Your Ref: EN010136 – Morgan Offshore Wind Project: Generation Assets
– Applicant's Response to Examining Authority's Second Written Questions

27 February 2025

SFF & West Coast Sea Products Ltd (WCSP) Response to the Applicant's Response to Examining Authority Written Questions 2 re Morgan Offshore Windfarm Generation Assets

Figure 1.1: Irish Sea queen scallop fishing grounds generated by digitising information provided in Vause et al, 2007, Defra, 2024 and plotter positions provided by WCSP.

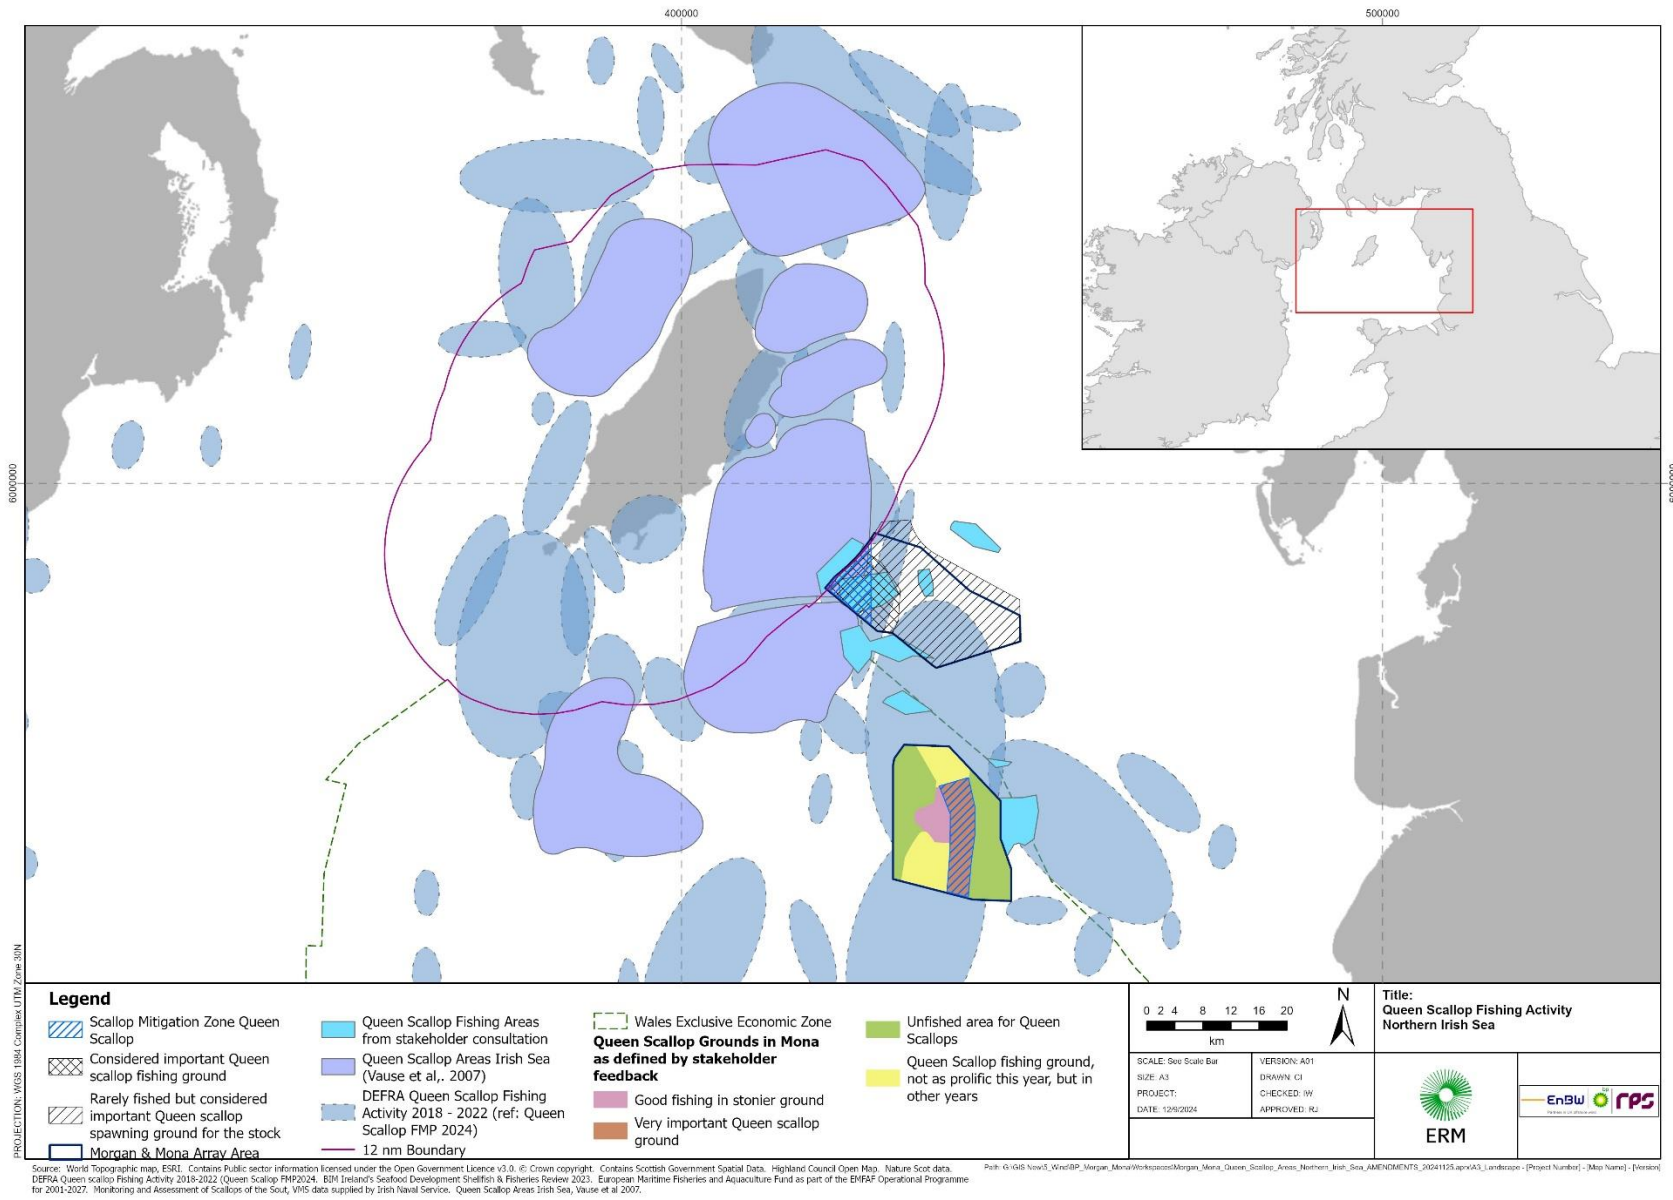
In terms of access to Irish Sea, following our response to the ExA's Q2, the diagram provided at **(Figure 1.1 of Annex 6.2 to the Applicant's response to Written Representations from MMO at Deadline 3: Queen Scallop)** is out of context as it tries to show the Queen Scallop grounds in the Irish Sea are vast and the development will have a negligible impact on Queen Scallop fisheries. This is not the case for the following reasons:

- The mentioned diagram (Figure 1.1) shows further Queen Scallop grounds in the Irish Sea, but it should be noted that our members (especially WCSP as the receptor affected) do not have access to the Queen Scallop grounds in Manx waters, which despite having historical rights, is now purely an otter trawl fishery for Queen Scallops.

- Secondly, the majority of the shown Queen Scallop grounds in Figure 1.1 are not prominent or commercially viable during a typical season, i.e. in some years there may be dense numbers of commercially viable Queen Scallops, but some beds can go years without any productivity. We would also like the opportunity to also highlight that the Morgan OWF and its SMZ is situated within the area of the Fishery management Plan currently being developed for English waters in which the attached document ([REDACTED] also attached with this response's email) evidences this as one of the most productive ICES rectangles for Queen Scallop commercial fishing.
